**DELEGATED LISTED BUILDING DECISION**

77891/APP/2024/2622 493 BATH ROAD LONGFORD

INVALID SAP - Replacing the front and rear doors and all windows.

TYPICAL SECTIONS
THROUGH WINDOWS

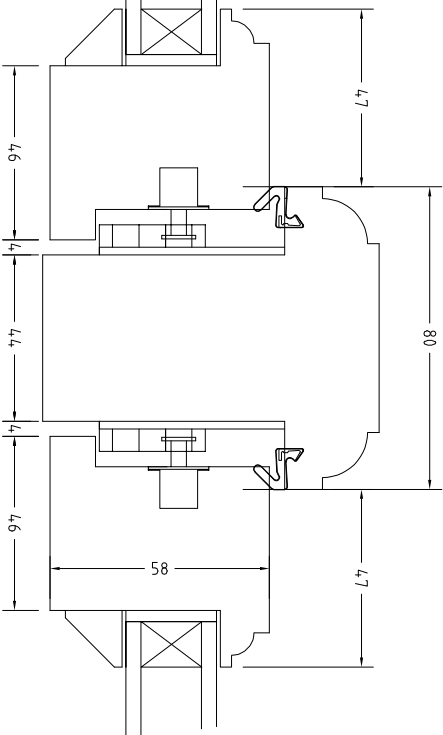
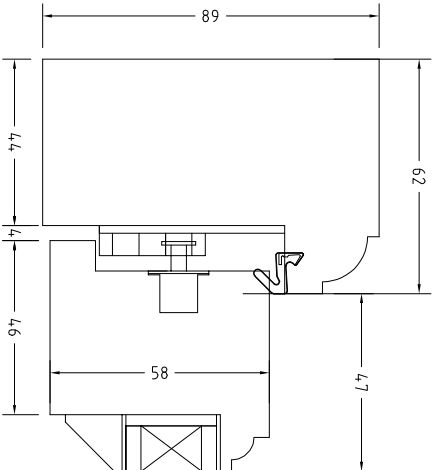
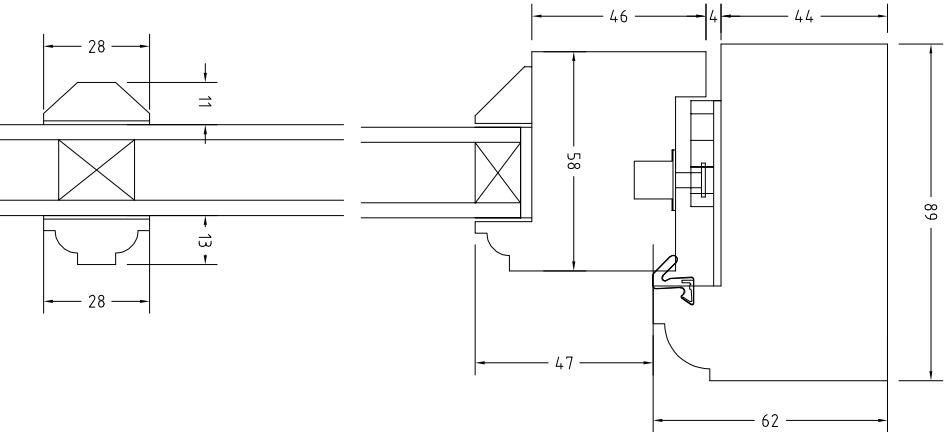
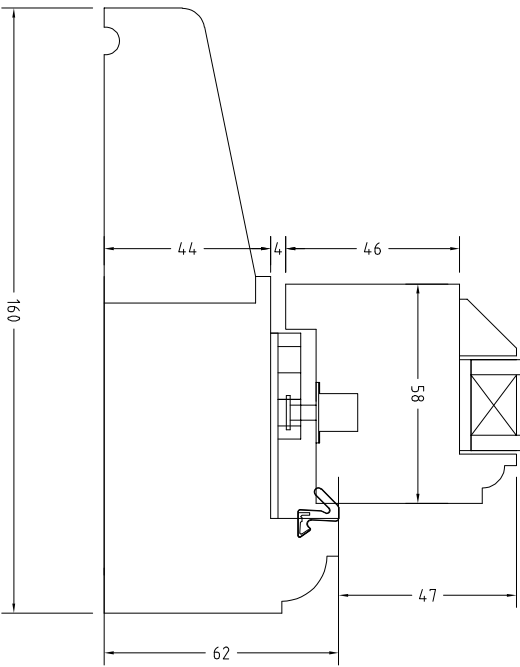
Although the existing windows are far more modern than the rest of the building, their frames are only a small proportion of the area of the window opening, and most of the existing windows are pairs of opening casements without a central mullion. The proposed design of the new windows makes the frames far heavier and inserts a central mullion rather than having the casements closing against each other. This gives a completely different external appearance, and incidentally reduces the area of glazing and thus the amount of light entering the house; as the windows are already relatively small this is an undesirable side effect of the proposals. It is not clear from the submitted plan (sheet E02) how or where the diamond leading will be applied to the glass, though it is clear that the proposal is an outer leaf of a single sheet of glass rather than a sheet of individual diamond panes held together by soldered lead cames. The effect will not be the same, but as a minimum the leading needs to be applied to the outside of the double-glazed unit.

I've checked the attached amended plans and can confirm that the drawings are acceptable. The glazing bar detail has been removed and the windows appear to be flush casements, which the notes confirm will have diamond leading to match existing.

Officer Comments: Following the above comments and consultation with the boroughs Conservation and Urban Design Officer, amendments were secured which proposed a flush casement design and diamond leading to match existing.
